# **Green Hill Solar Farm**

## **EN010170**

### **Written Summary of the Oral Submissions at the Open Floor Hearing 1 and the Applicant's Responses**

Document Reference: EX3/GH8.1.23

Title:  
Figure 16.4 BESS Fire Emissions Study Area,  
Receptors and Modelled BESS Locations

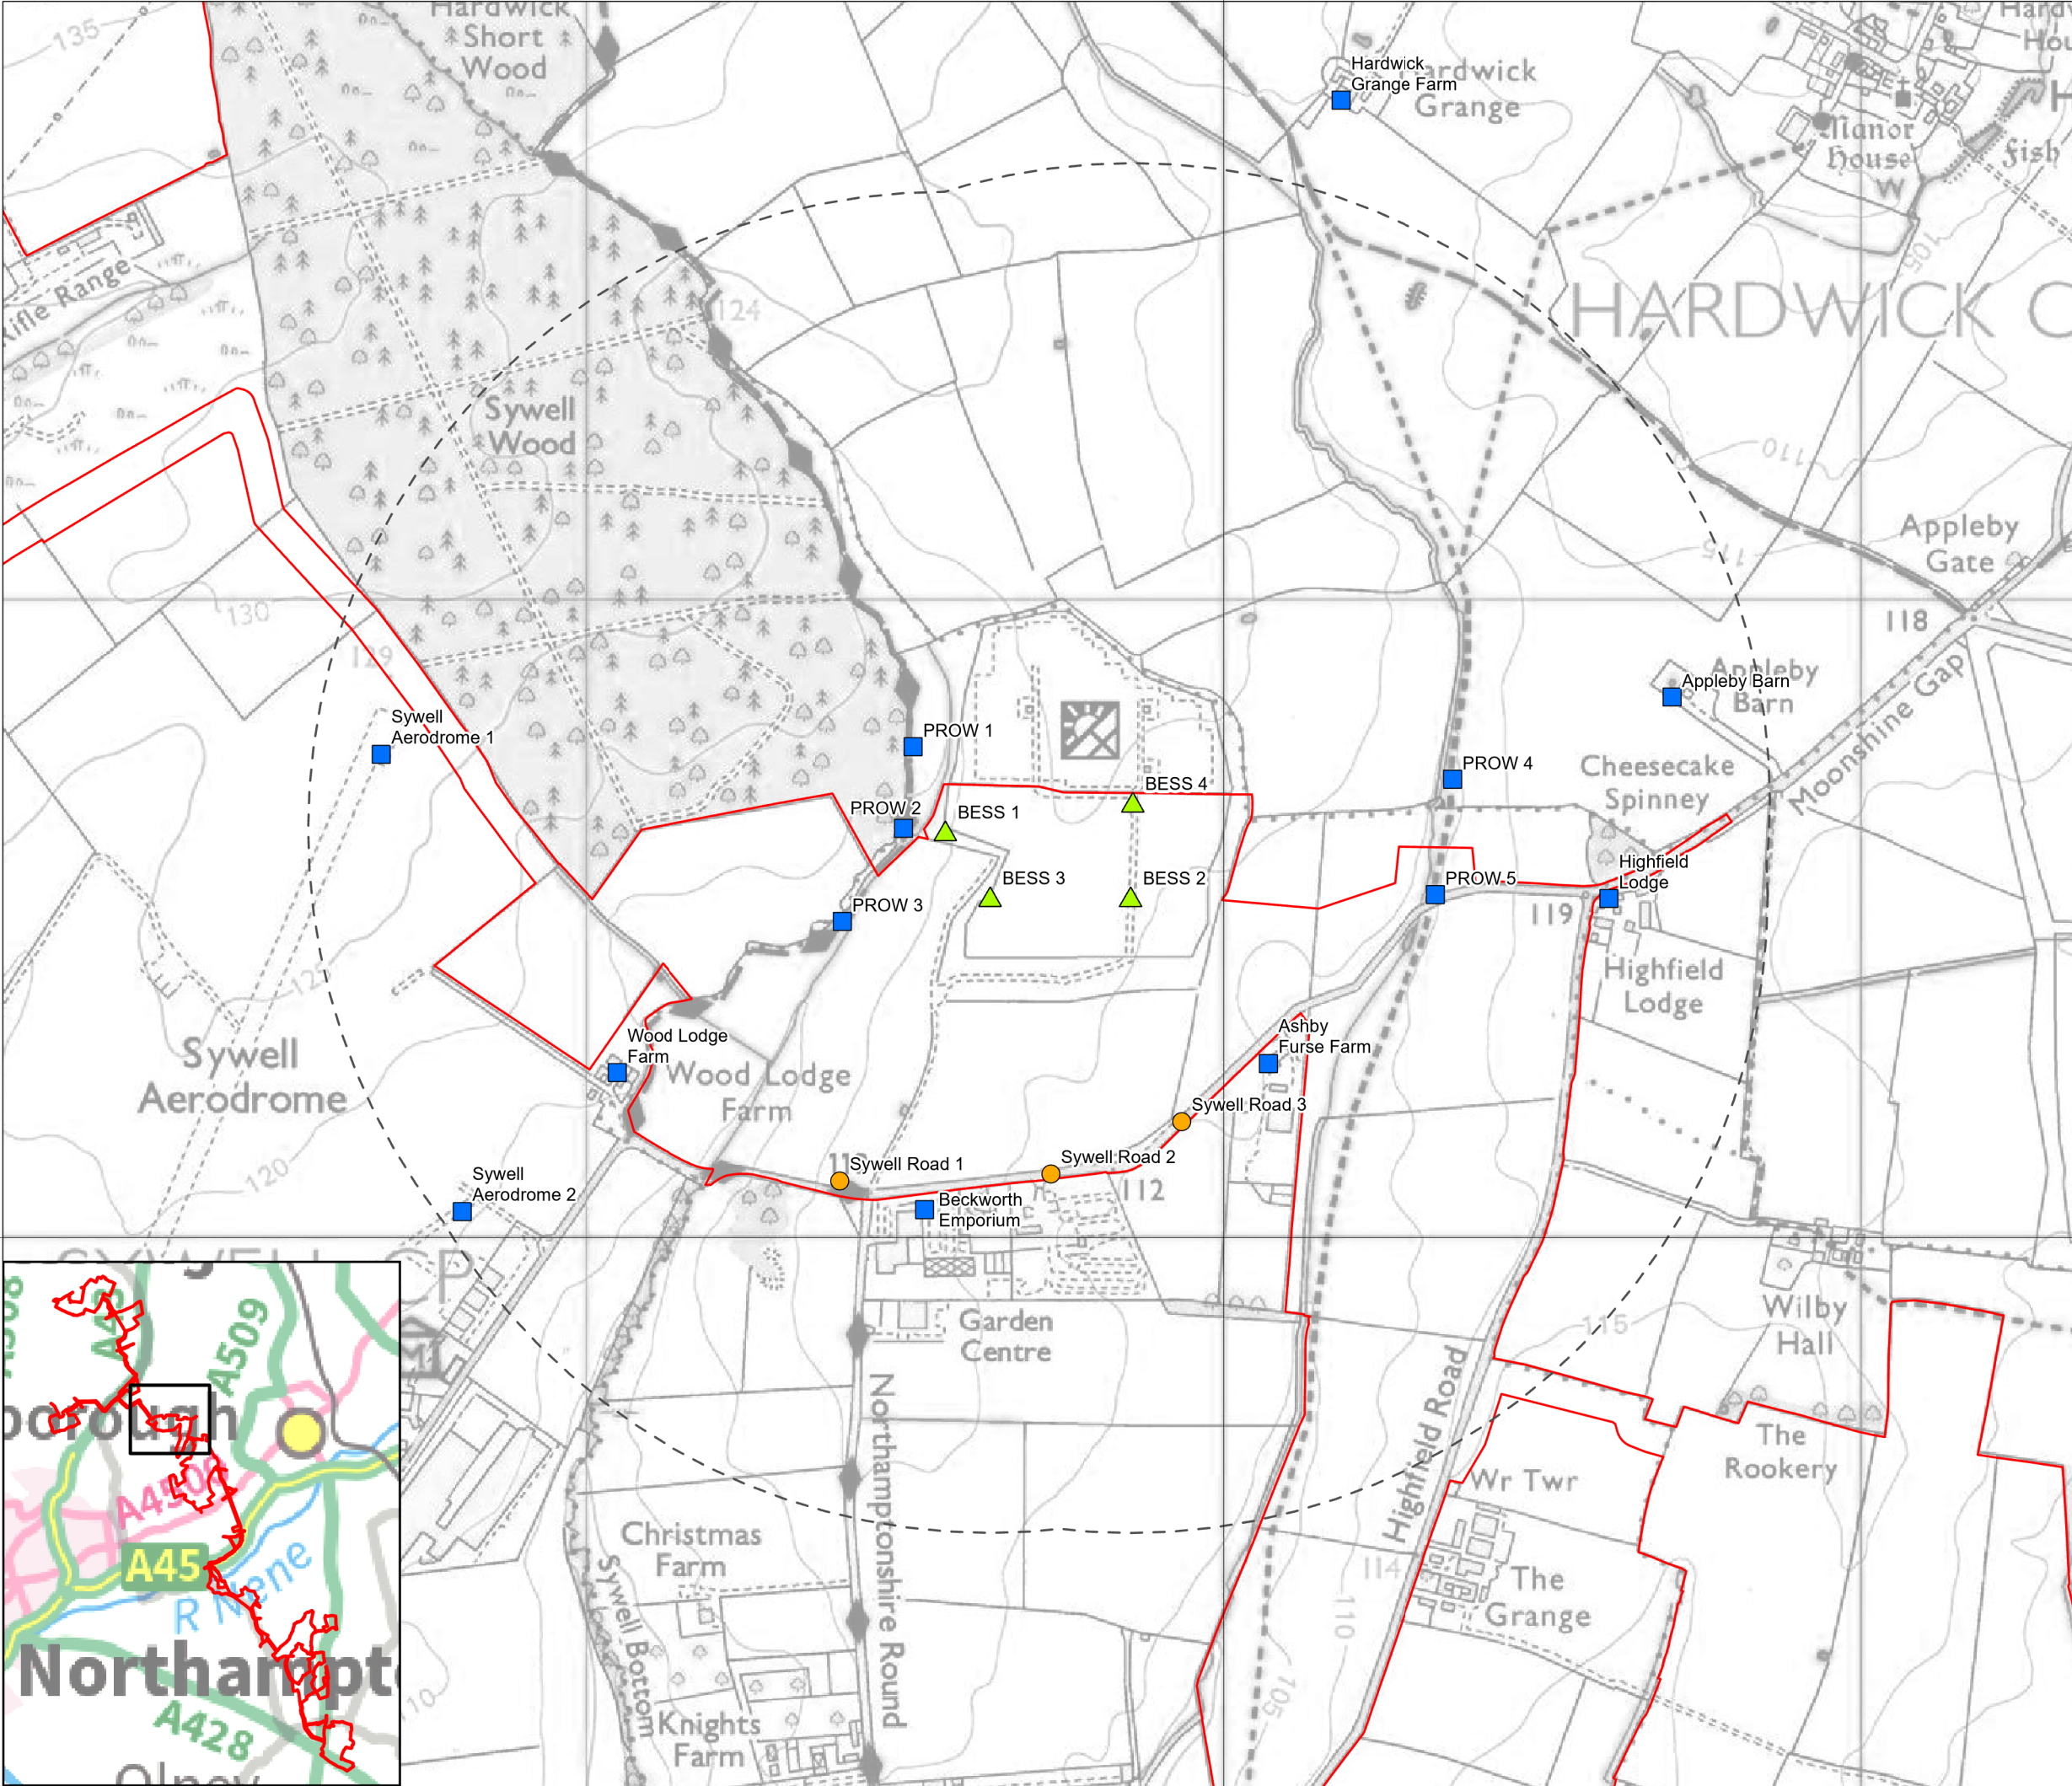
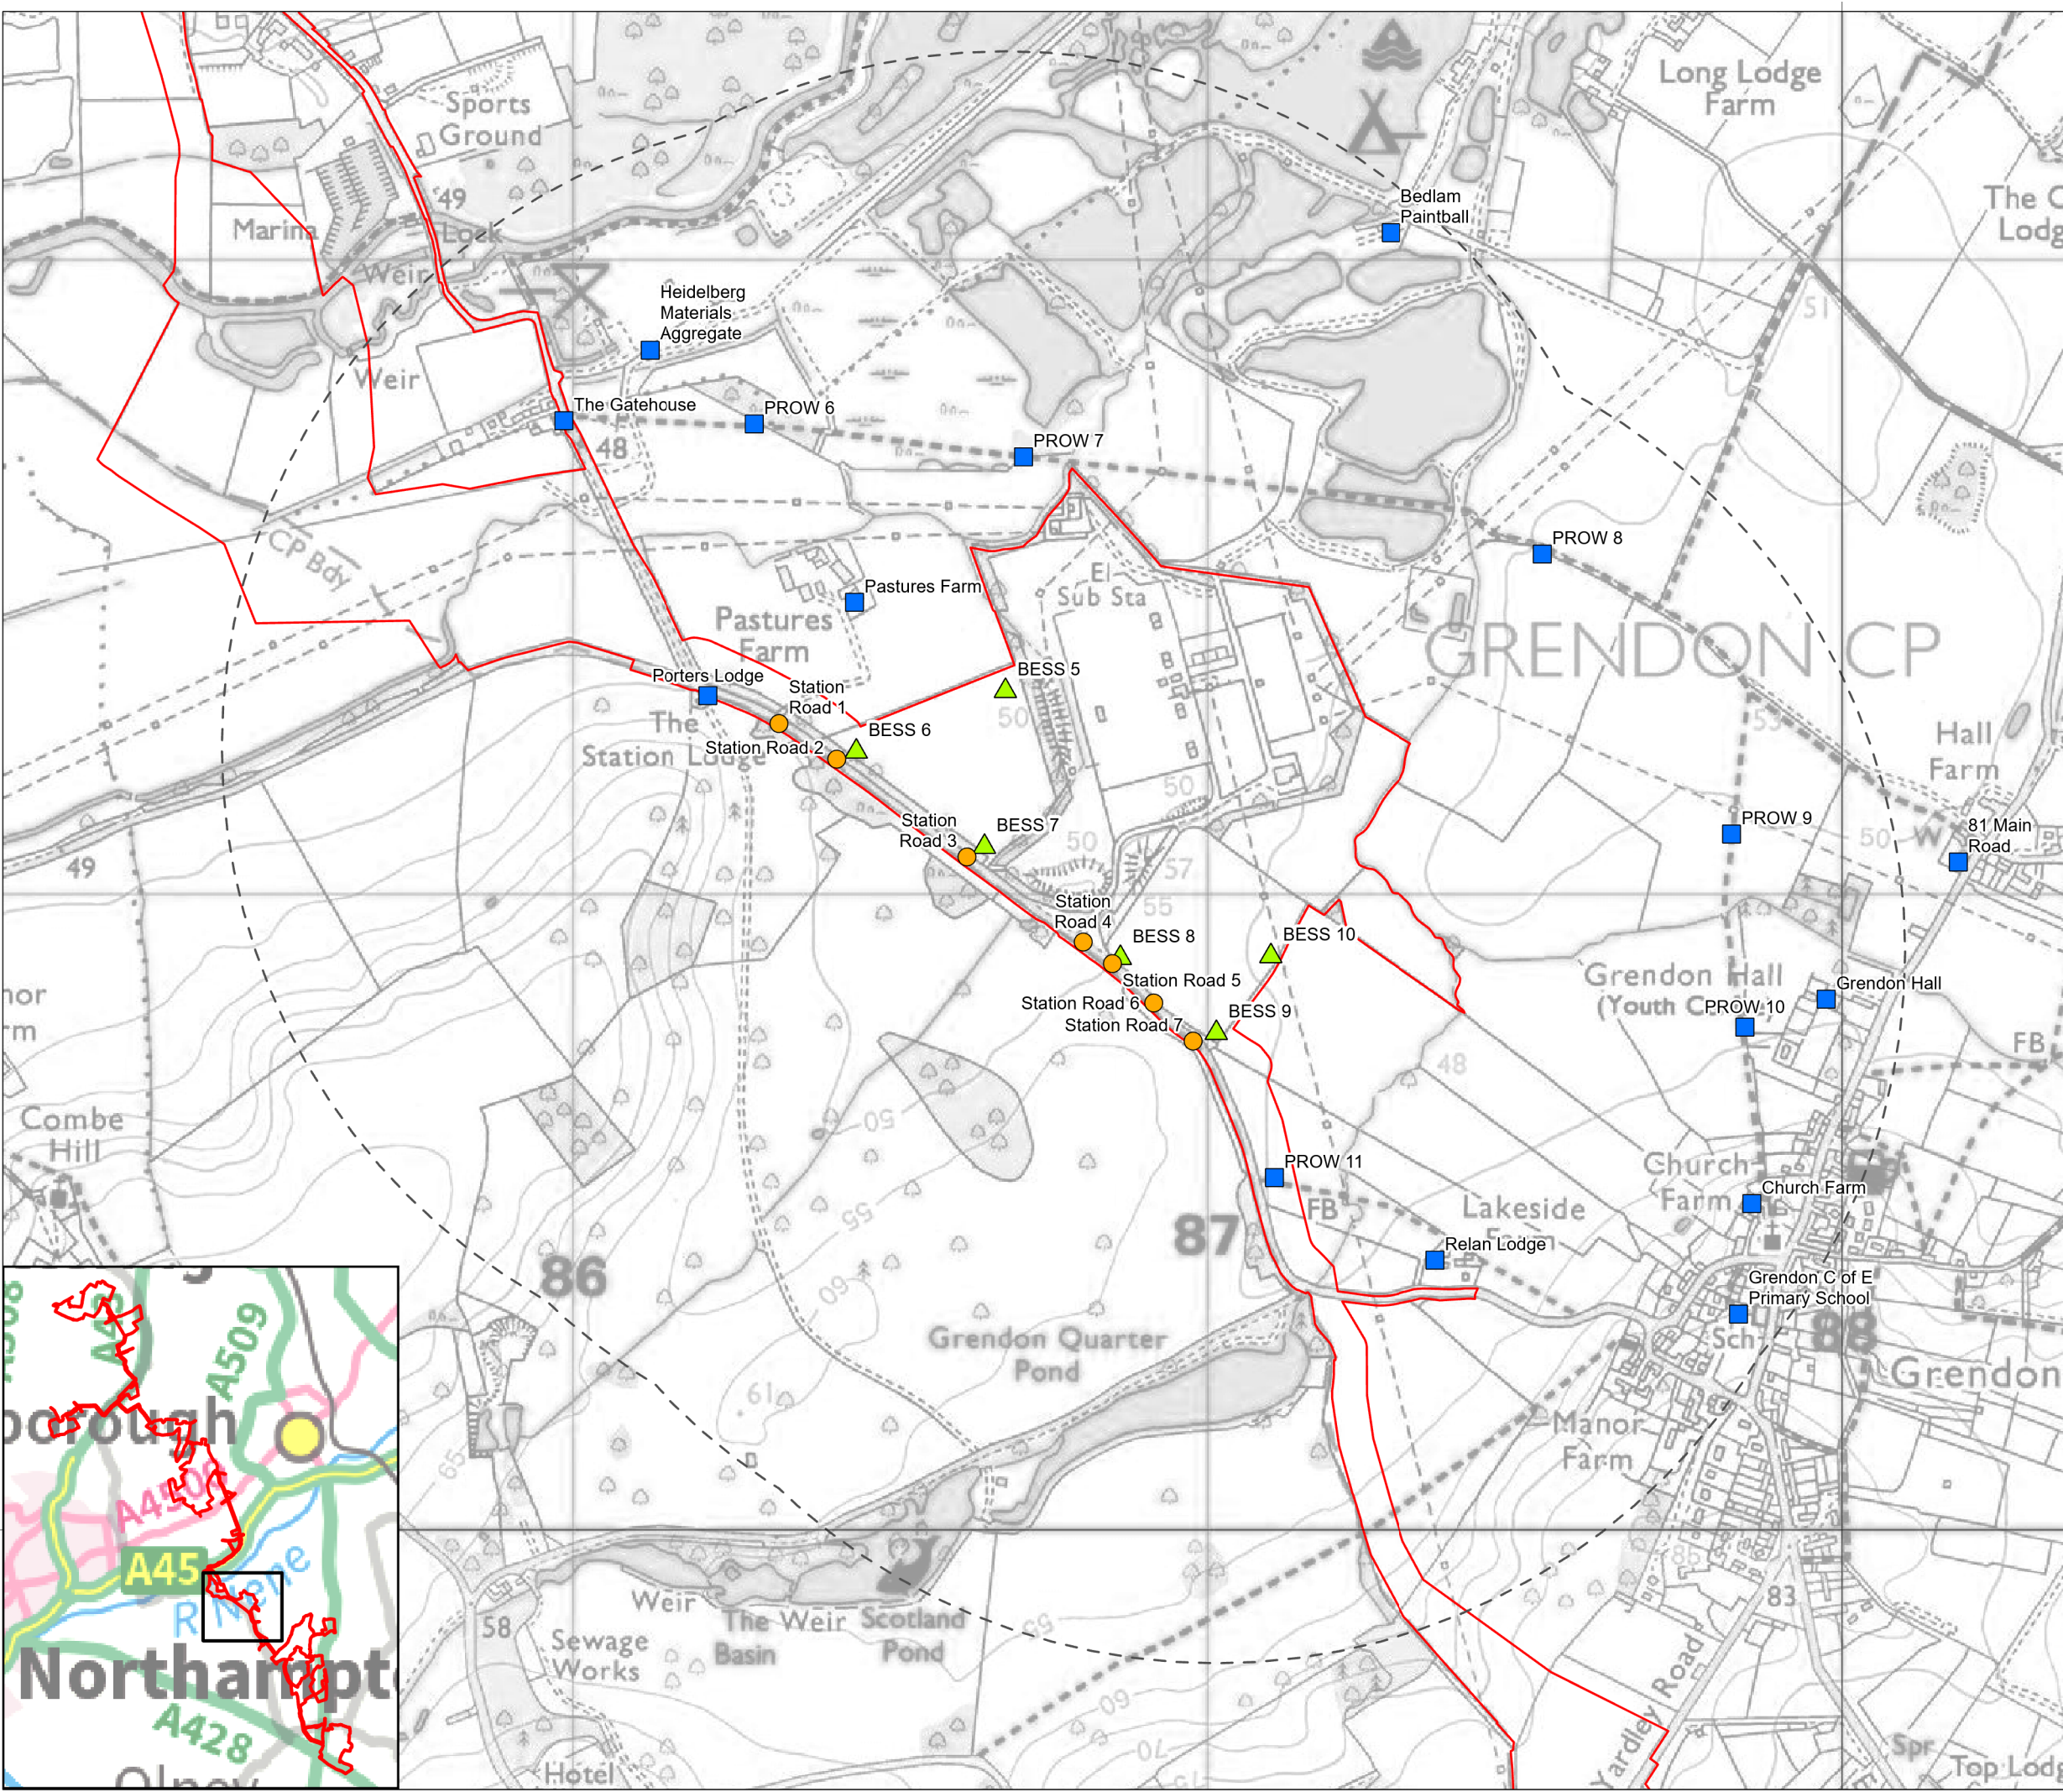
NF-005	Hydrology and Flood Risk	Contamination of water	<p>Mr. Frampton raised concerns about the proposed battery storage facility at BESS Green Hill C, located less than 300m from Beckworth Emporium. Comments noted that battery storage systems are considered inherently unsafe, with fires becoming increasingly common, and stated that placing such a facility so close to a major retail outlet is unprecedented.</p> <p>Mr Frampton referred to concerns about the absence of any detailed</p>	<p>The Applicant strongly emphasises that BESS are not inherently unsafe, the safety risks of BESS are well established in 2025; the Electric Power Research Institute (EPRI) BESS Failure Incident Database was established in 2021 as an information tool for both energy storage industry stakeholders and the public. Statistically, the significant global increase in BESS deployments means that there will be a likely increase in the number of failure</p>

Reference	Theme	Issue	Comments/Issue Raised	Applicants Response
			<p>safety assessment and highlighted that a fire at BESS C, combined with a north wind, could have catastrophic consequences for Beckworth Emporium.</p> <p>Mr Frampton also noted that just 30m downslope from the corner of BESS C lies a stream called Sywell Bottoms, which feeds directly into Sywell Reservoir.</p> <p>Mr. Frampton raised concerns that contaminated water runoff following a fire could enter this stream, causing an ecological disaster for Sywell Country Park, which is home to important wildlife habitats, the county's top tench fishery, and a popular open-water swimming venue.</p>	<p>events. However, BESS failure rates dropped by 98% from 2018 to 2024 as lessons learned from BESS failure events have been incorporated into BESS design, testing requirements, control and monitoring systems, safety standards, and construction and operations best practices.</p> <p>Electric Power Research Institute (EPRI), <i>Insights from Battery Energy Storage Systems (BESS) Failure Incident Database: Analysis of Failure Root Cause</i>, identified four primary root causes of BESS failure with the majority occurring in early lifecycle stages i.e. construction, commissioning, or within two years of operation. The Applicant emphasises that the EPRI research concluded that the primary cause of failure was rarely the battery cells or modules, and the <b>Outline Battery Storage Safety Management Plan [REP1-143]</b> (OBSSMP) is drafted to address all key safety risk reduction topics to ensure that comprehensive BESS fire and explosion hazard prevention and mitigation strategies can be developed and implemented.</p> <p>The Applicant commissioned a Plume Study: <b>BESS Fire emissions</b></p>

Reference	Theme	Issue	Comments/Issue Raised	Applicants Response
				<p><b>modelling report [APP-167]</b> to assess fire emission impacts on all sensitive receptors within a 1km radius of both BESS areas (Green Hill BESS and Green Hill C).</p> <p>Beckworth Emporium is located 496 metres from the BESS area; the plume study modelling (page 12) demonstrates that in a worst-case climate condition a single BESS enclosure fire emissions are at safe levels at this location i.e. all emissions are below 1PPM.</p> <p>As stipulated in Section 5.5.9 of the <b>Outline Battery Safety Management Plan Rrevision A (OBSSMP) [APP-551]</b>:</p> <p><i>“at the detailed design stage a BESS system and site specific Plume Analysis study will be conducted to assess the environmental impact of a site incident to sensitive receptors within a 1 km radius. Toxic gas emissions to sensitive receptors must be below relevant public health exposure limit guidelines when the battery system of a BESS is fully consumed (burnt out), production of Particulate Matter (PM) and a visibility impact assessment on any</i></p>

Reference	Theme	Issue	Comments/Issue Raised	Applicants Response
				<p><i>transport links within a 1 km radius of the BESS area will also be included. The emergency response plan (ERP) produced at the detailed design stage (template outlined in section 5.4.4) will incorporate all necessary emergency response procedures and actions based upon thermal runaway test data supplied by the BESS system provider."</i></p> <p>All data provided by the BESS system provider is validated by accredited third party test laboratories and specialist BESS independent fire protection engineers.</p> <p>Section 5.5.8 of the OBSSMP documents:</p> <p>The Plume Study contained Chapter 16: Air Quality [APP-053] of the ES (and associated Appendices) assesses the battery fire emission impact in ten worst case fire locations (using the concept BESS design) on sensitive receptors within a 1 km radius of the BESS area.</p> <p>The Plume Study considers all toxic emissions at the peak of a BESS fire, all emissions at receptor locations were below all relevant public health</p>

Reference	Theme	Issue	Comments/Issue Raised	Applicants Response
				<p>exposure limit guidelines throughout the timeframe when the battery system of the indicative BESS design was fully consumed (burnt out).</p> <p>Section 2.4.2 of the OBSMP specifies that:</p> <p>Final BESS design and site layout will have been validated through mandatory Large Scale Fire Testing (LSFT) and rigorous consequence modelling to minimise the requirement for any NFRS intervention in a thermal runaway incident. LSFT must establish minimum equipment spacing distances that demonstrate there is no fire propagation to adjacent BESS enclosures or Energy Storage System (ESS) equipment. NFRS intervention in worst case scenarios would typically be limited to boundary cooling of adjacent BESS and ESS units to prevent the fire from spreading. This strategy will be finalised with Northamptonshire Fire and Rescue Service (NFRS) and be clearly communicated in the Emergency Response Plan (ERP):</p> <ul style="list-style-type: none"><li>• To ensure that fire, smoke, and any release of toxic gases does not</li></ul>
